Case Officer: Andrew Thompson

Applicant: Begbroke Oxford Limited

Proposal: Amended wording of condition 2 to allow changes to the approved plans regarding the location of the gas store (proposed as non-material amendment to 21/03150/REM)

DRAWING NUMBER: ISSUE:
BBSP-NBBJ-CB-00-DR-A-501020 **C03**

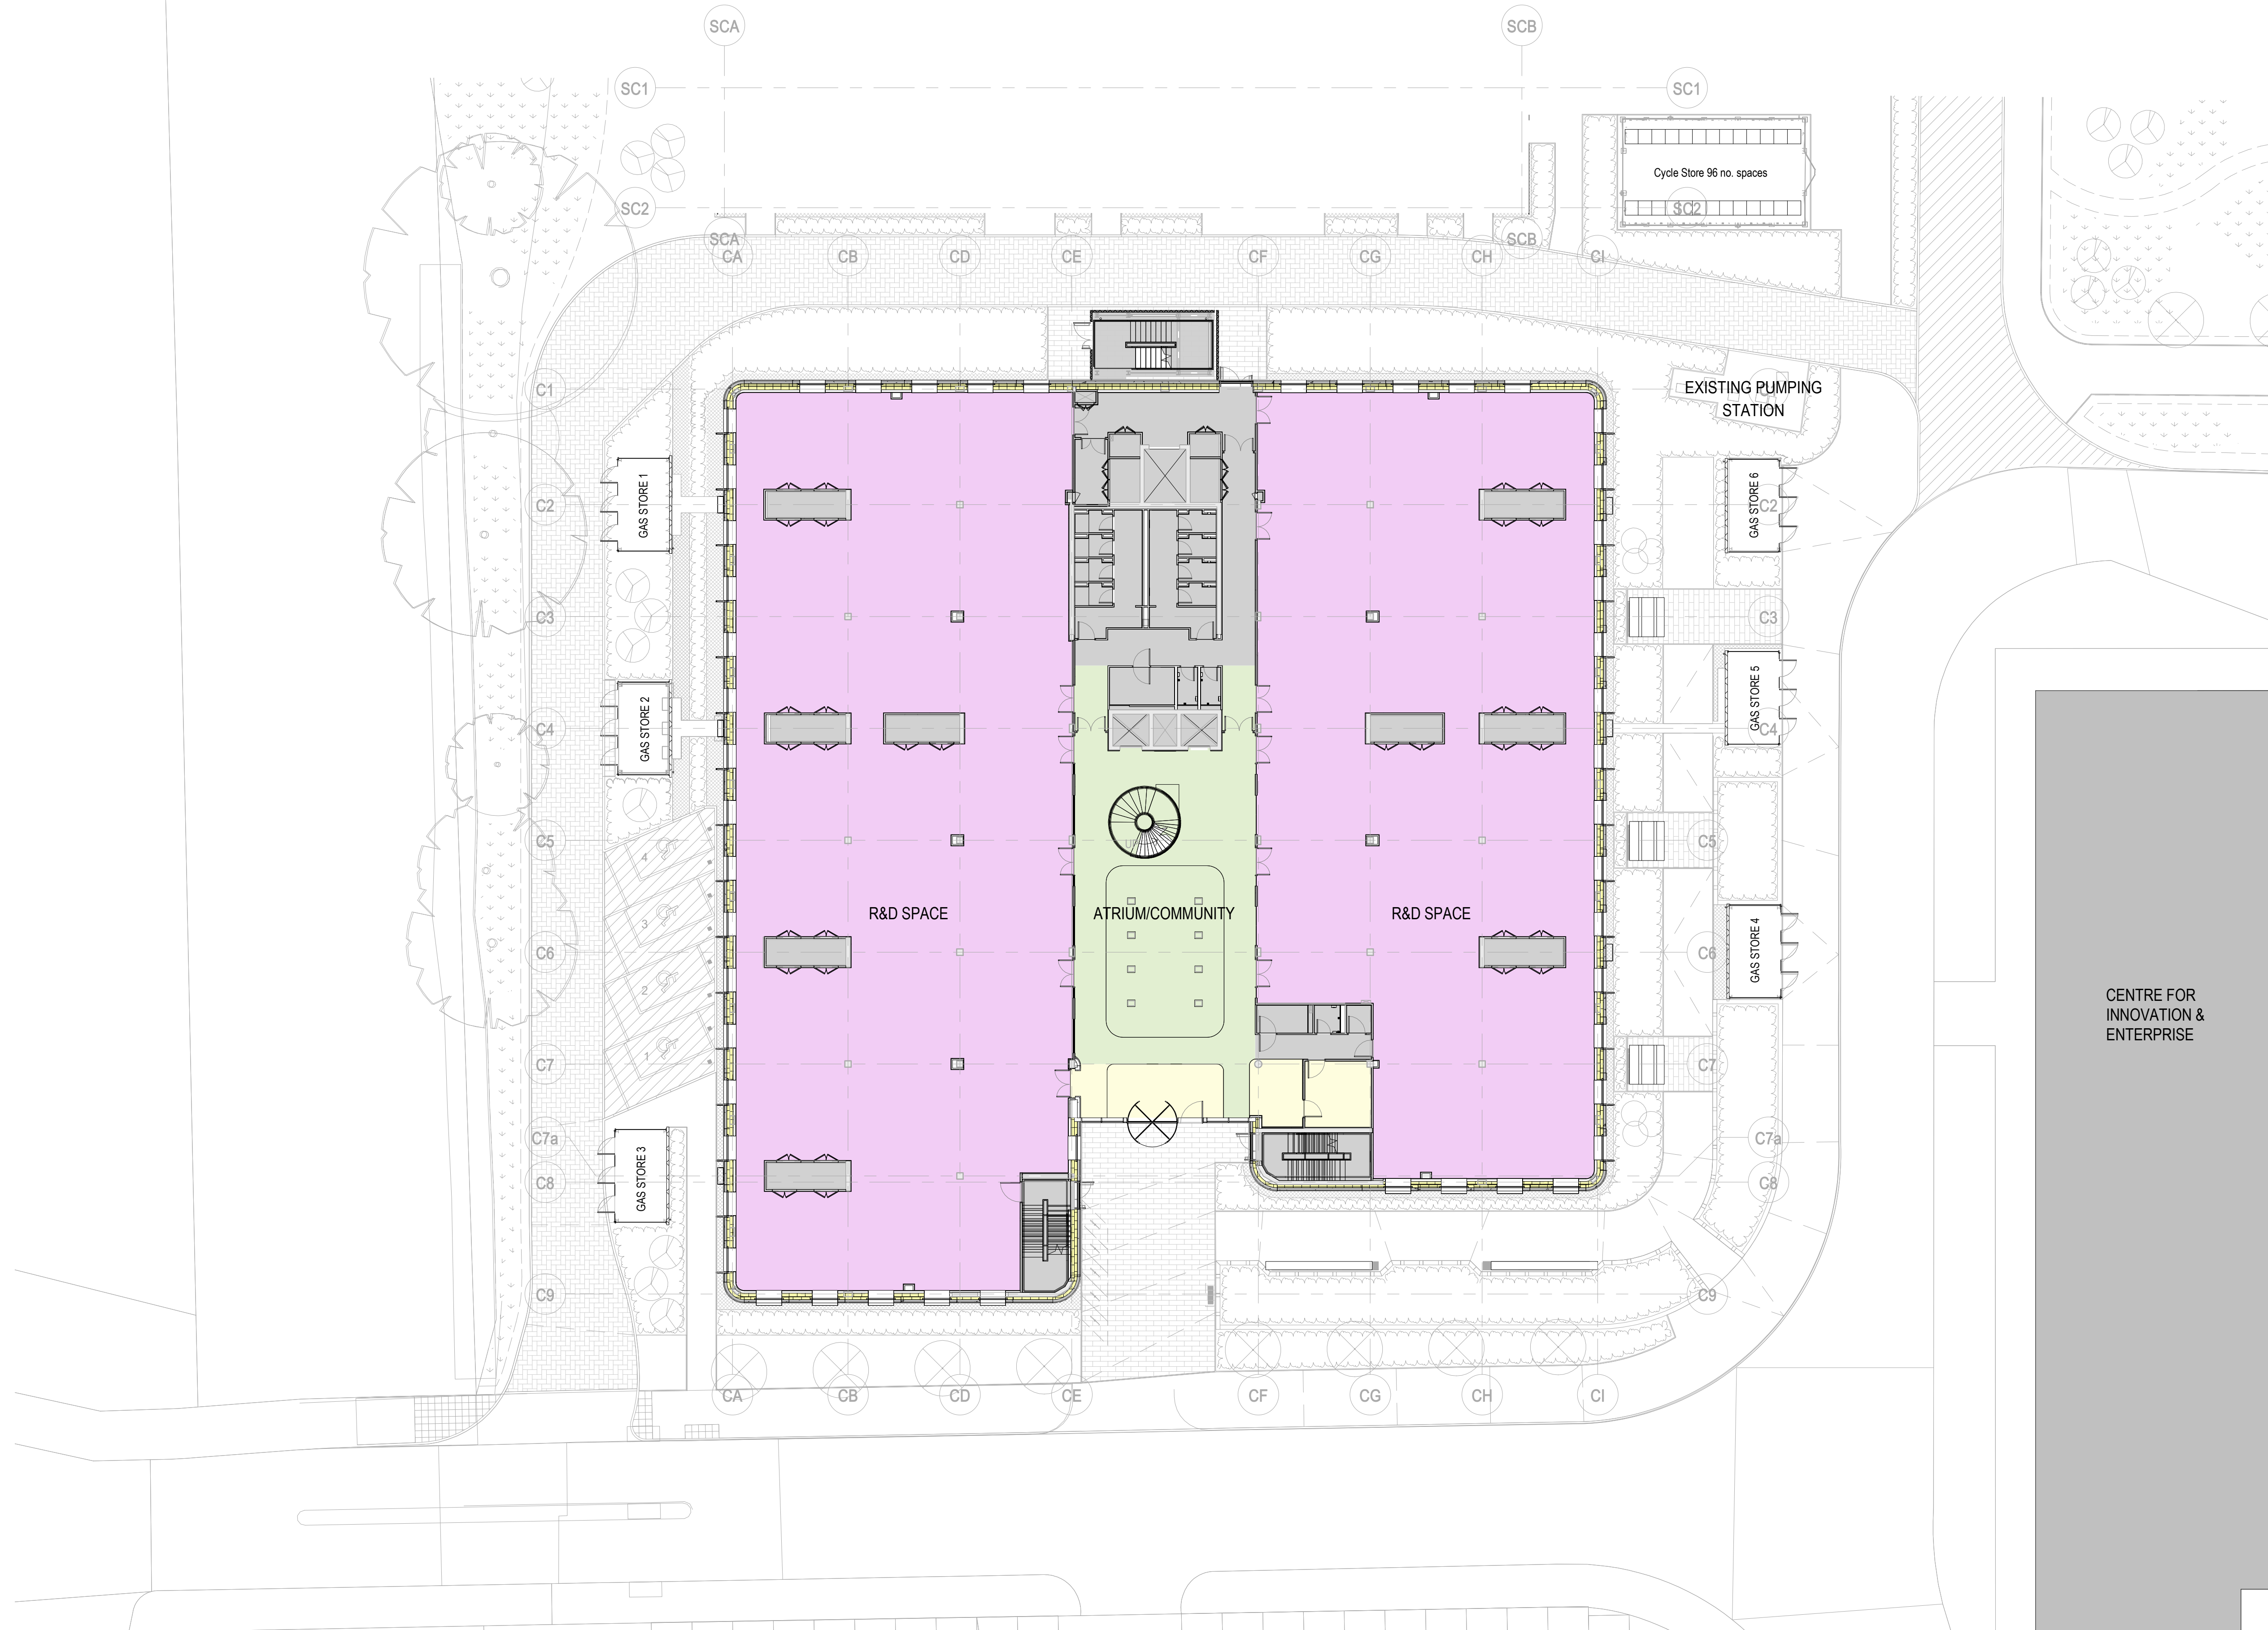
- 5.4. The proposed alteration is to move one of the gas stores 1.8m to the north. There are no other changes proposed. The location and design of the gas store is

considered against the setting of the main commercial building with the design unaltered. The revised location is not materially different from the approved plan and is not considered to be a significant alteration to the approved plans.
